**Consultation Response from KC,
Trees**

2025/90033 adj, 916, Halifax Road, Hartshead Moor, Cleckheaton, BD19 6LR

Erection of 11 dwellings with access from Halifax Road and associated works.

Date Responded: 10/06/2025

**APPENDIX F
DRAINAGE LAYOUT**

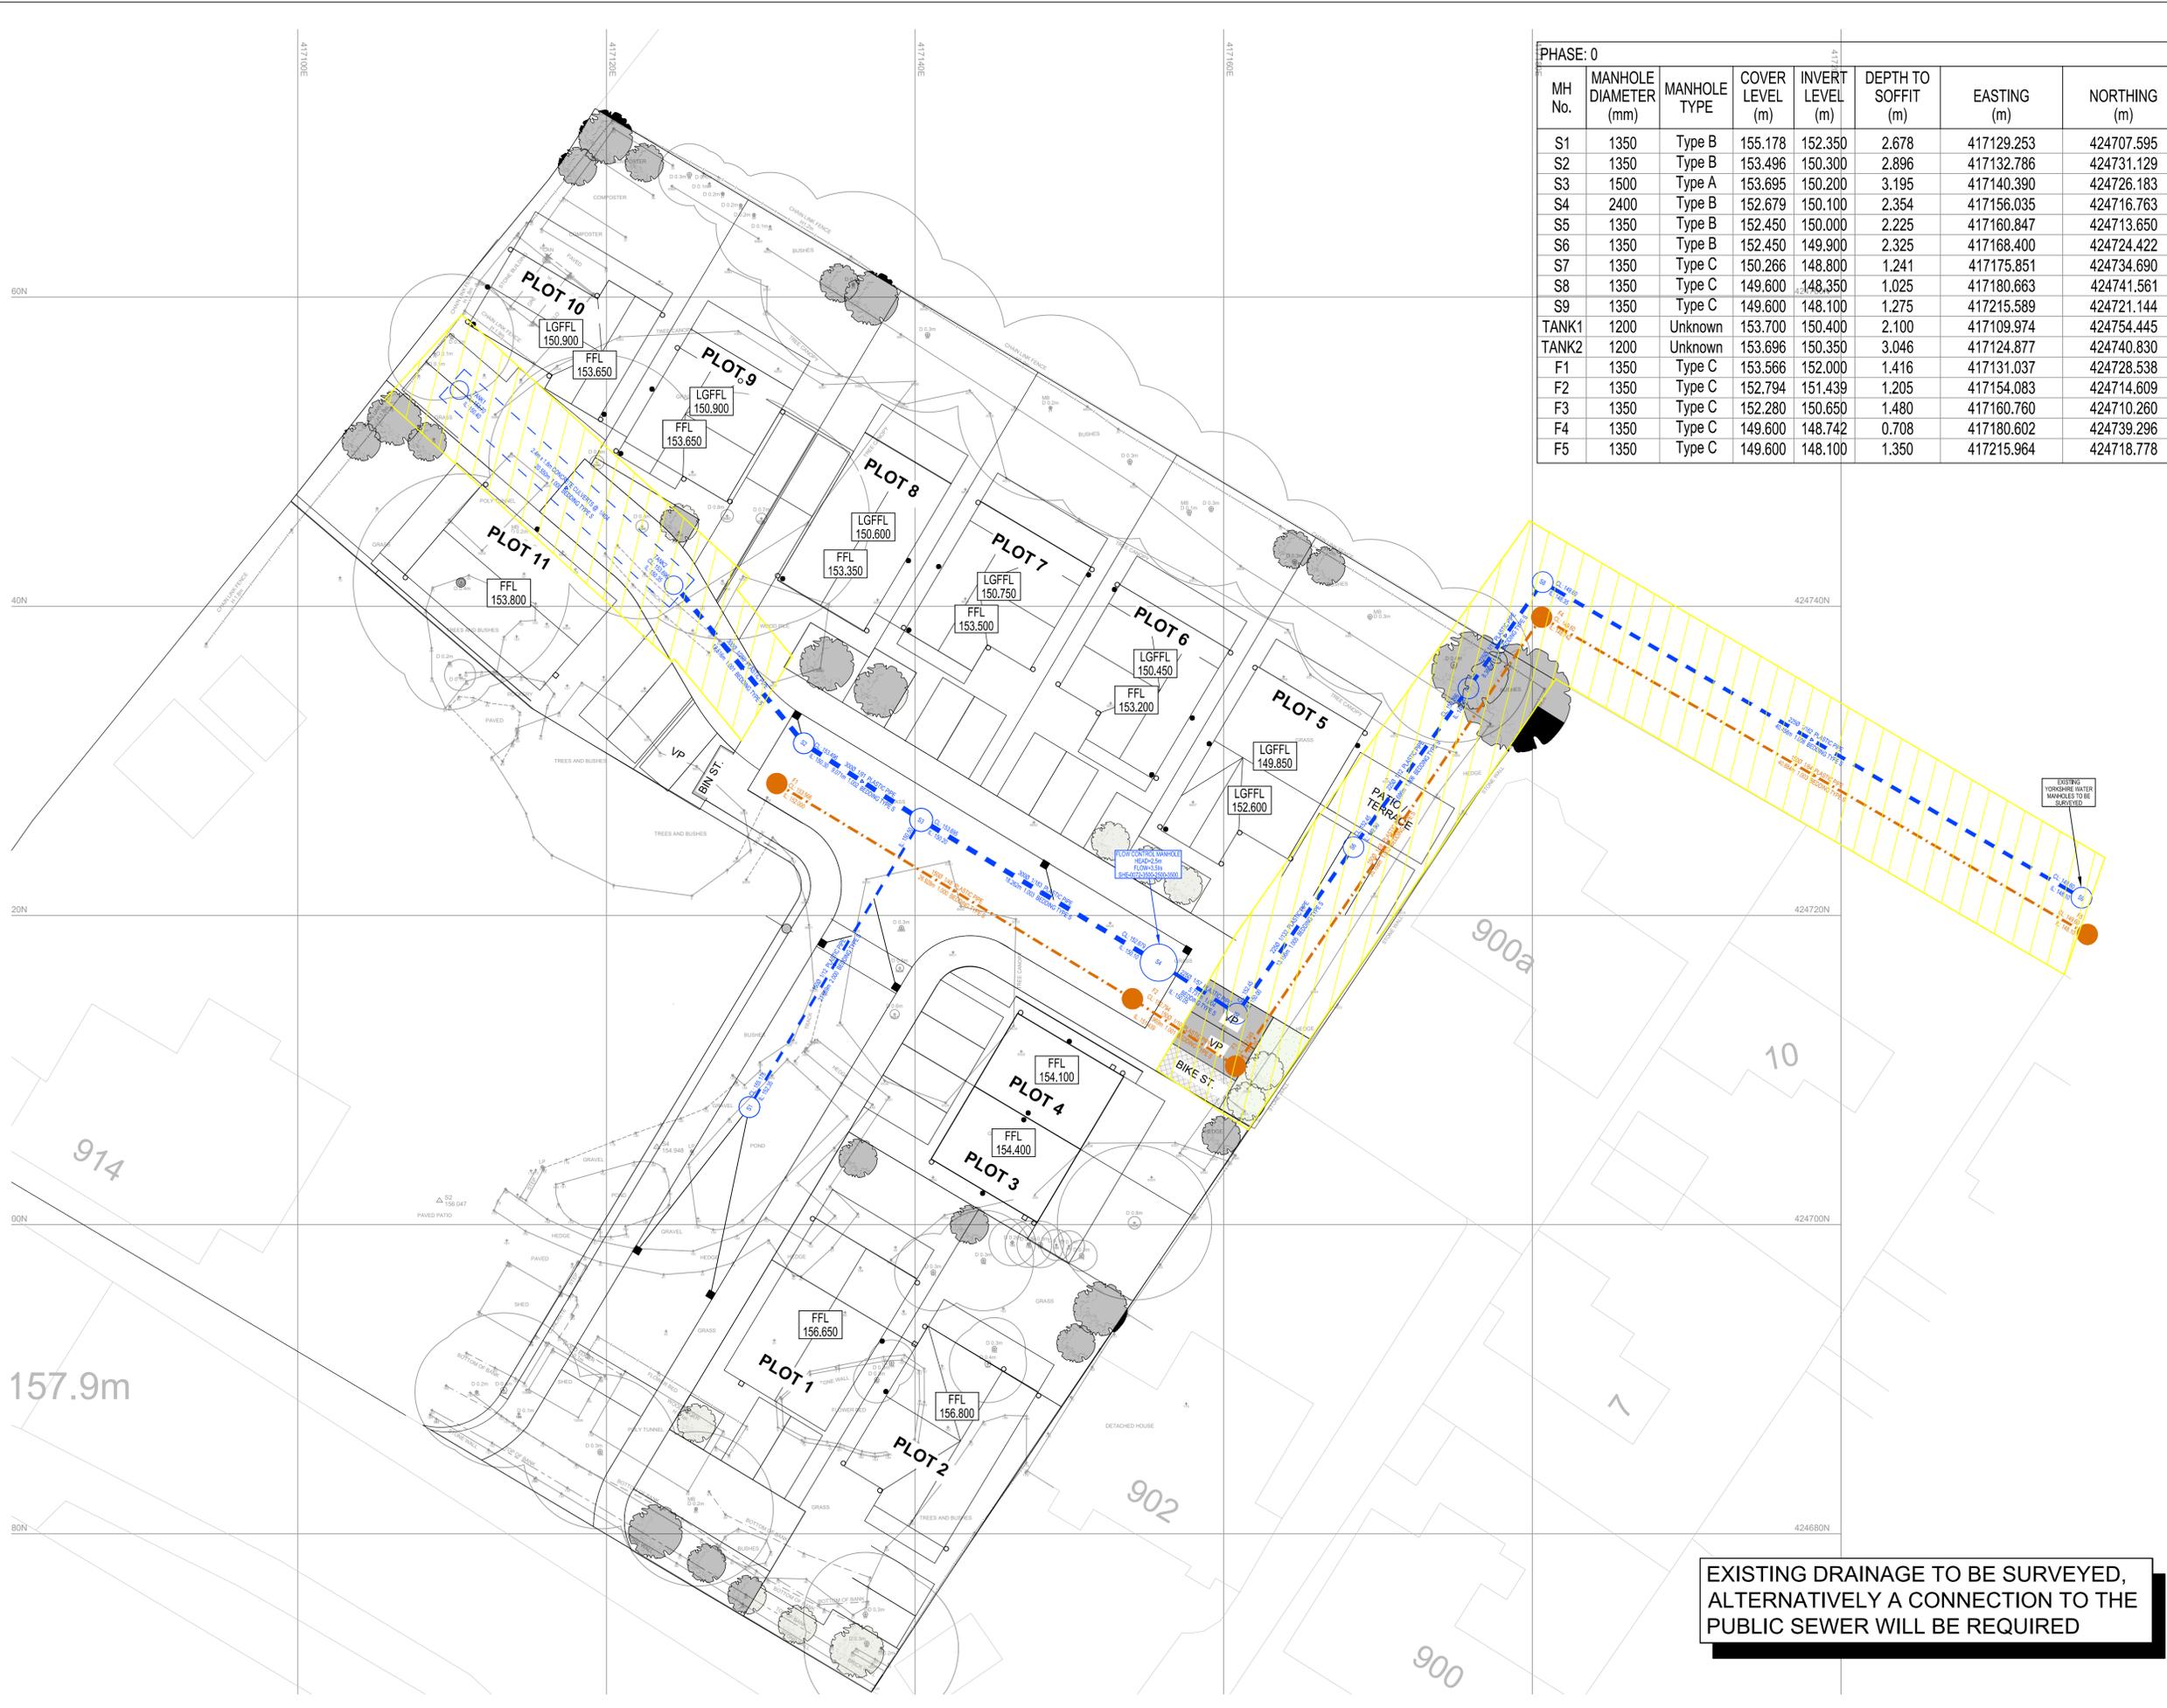
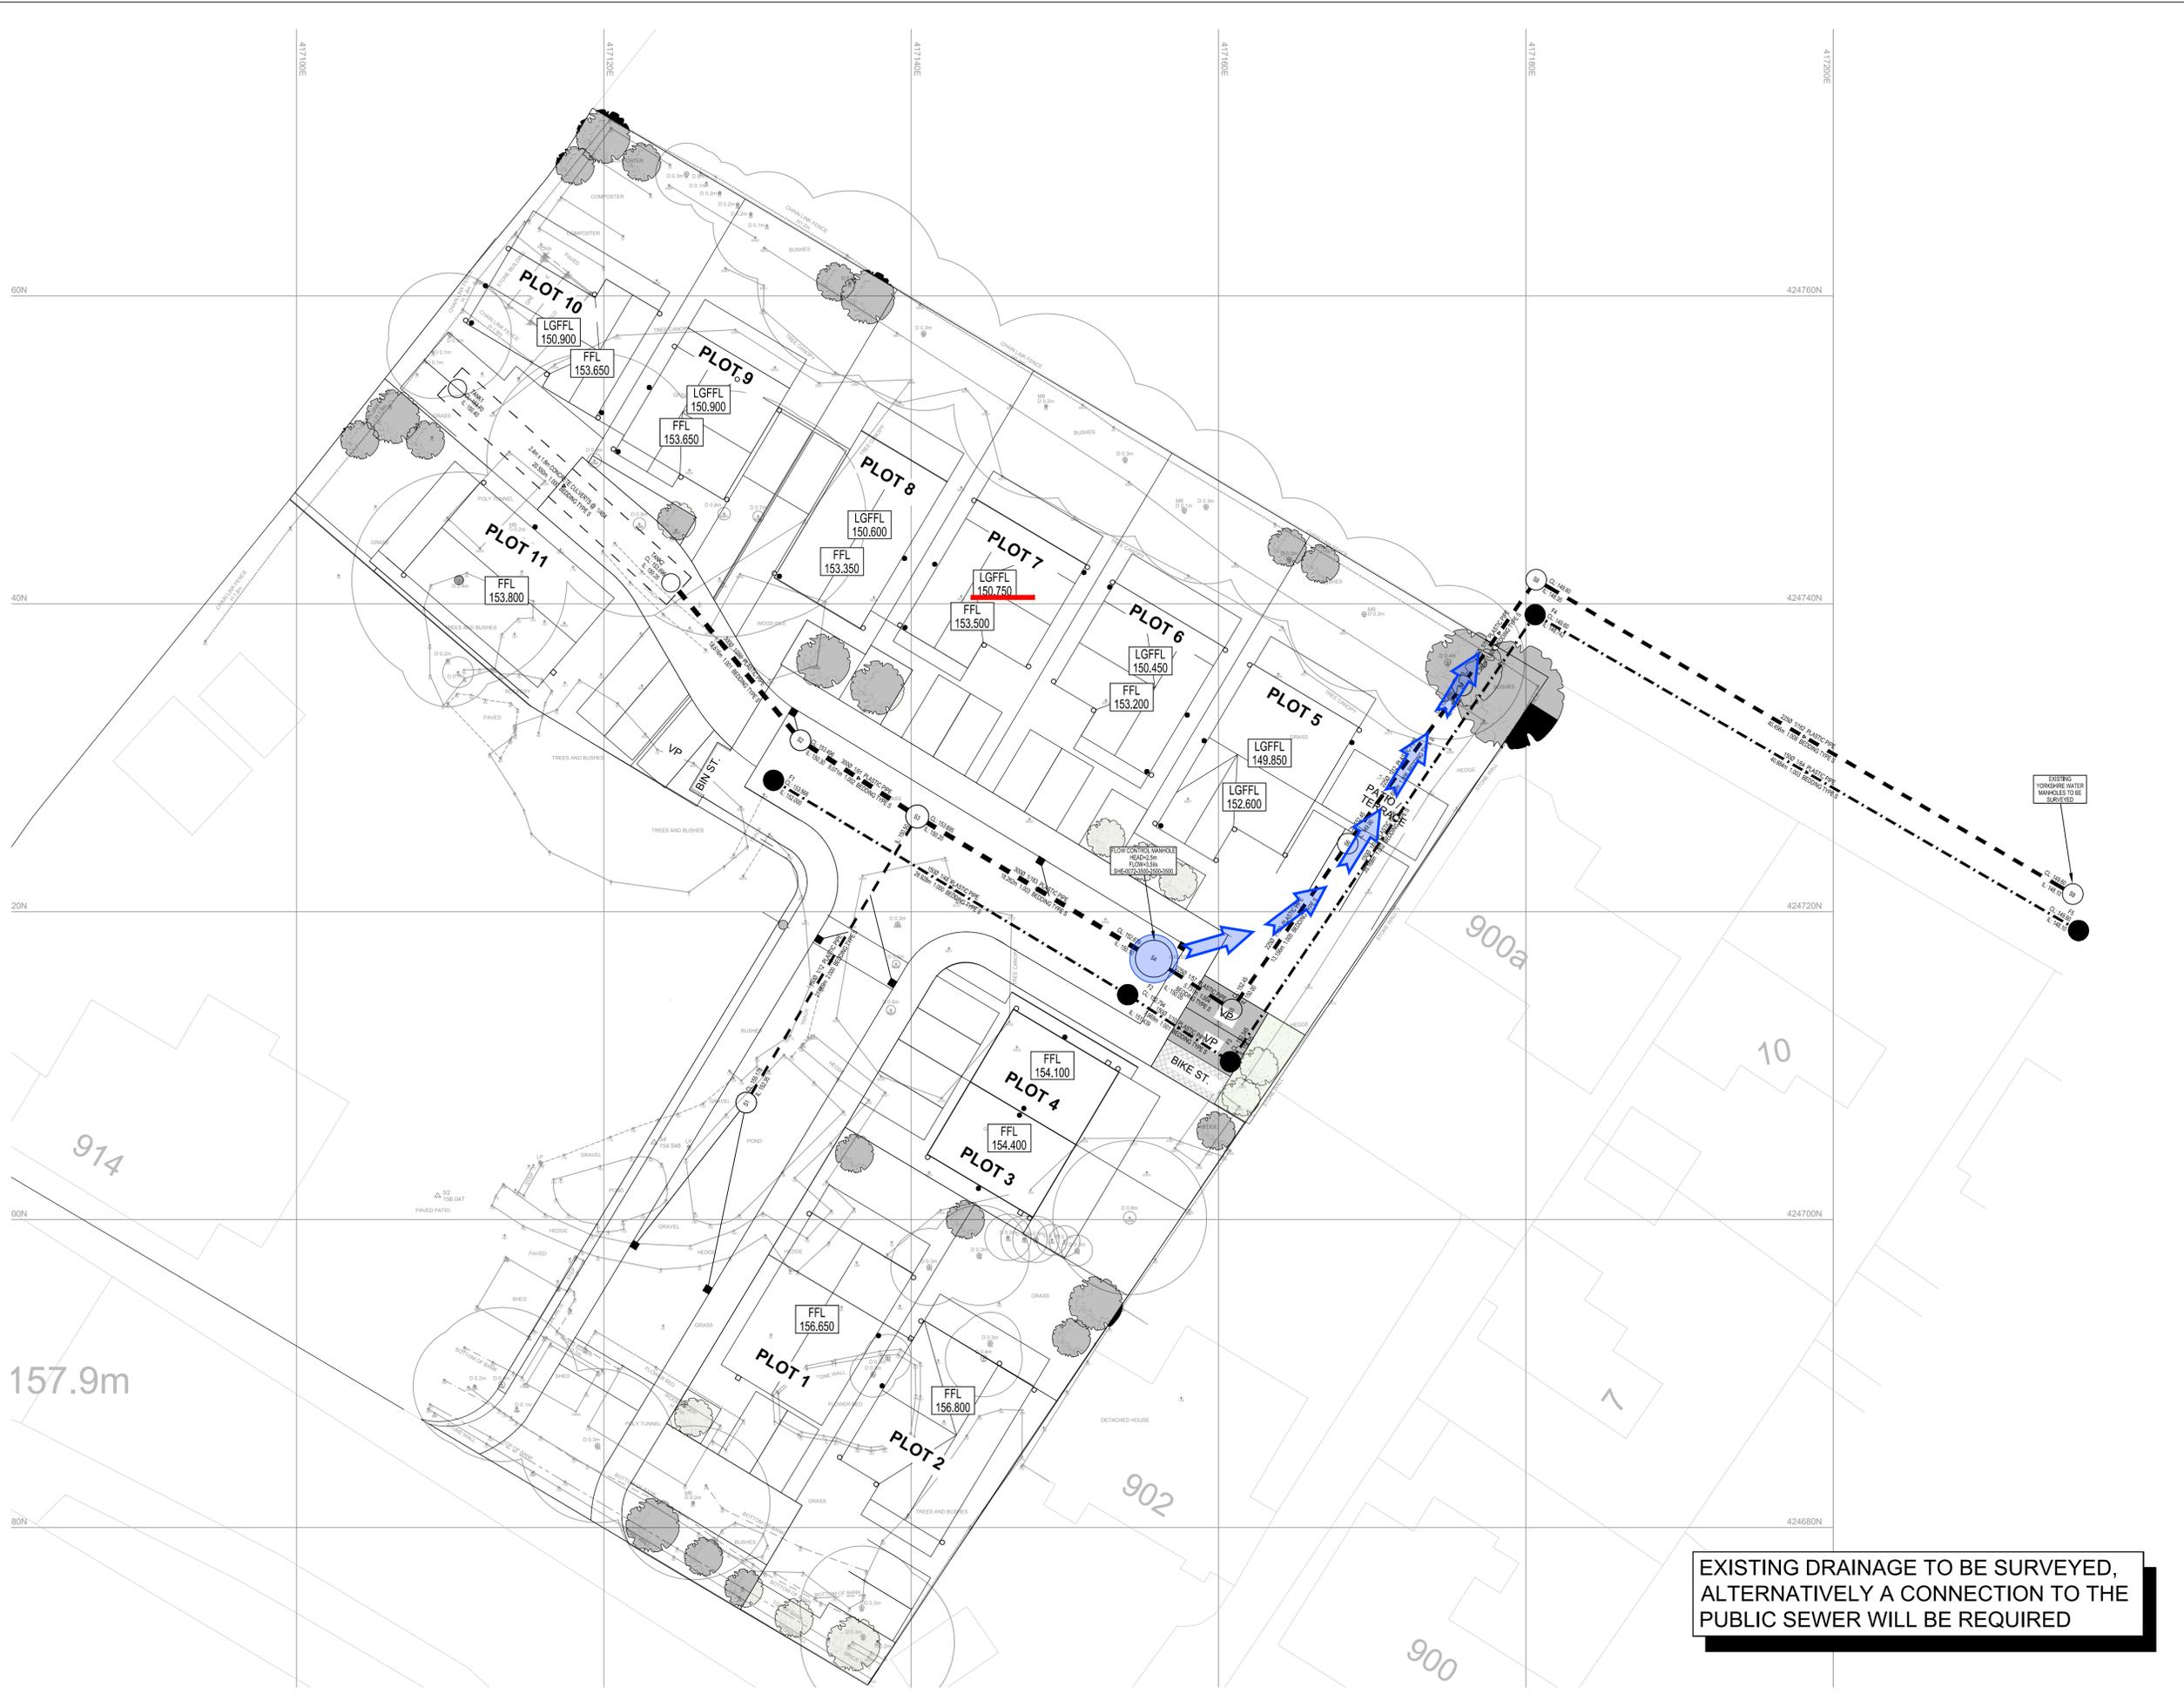
The drainage layout has not been assessed as part of the Arboricultural impact assessment. However, from the submitted drainage layout, two drainage pipes are routed through retained trees forming part of Category B Group G3, towards the northeast corner of the site. H7, on the Western boundary of the site would also be impacted by the drainage proposals.

Should an amended layout be submitted, a new AIA would be required, including the details of the drainage/ utilities layout.
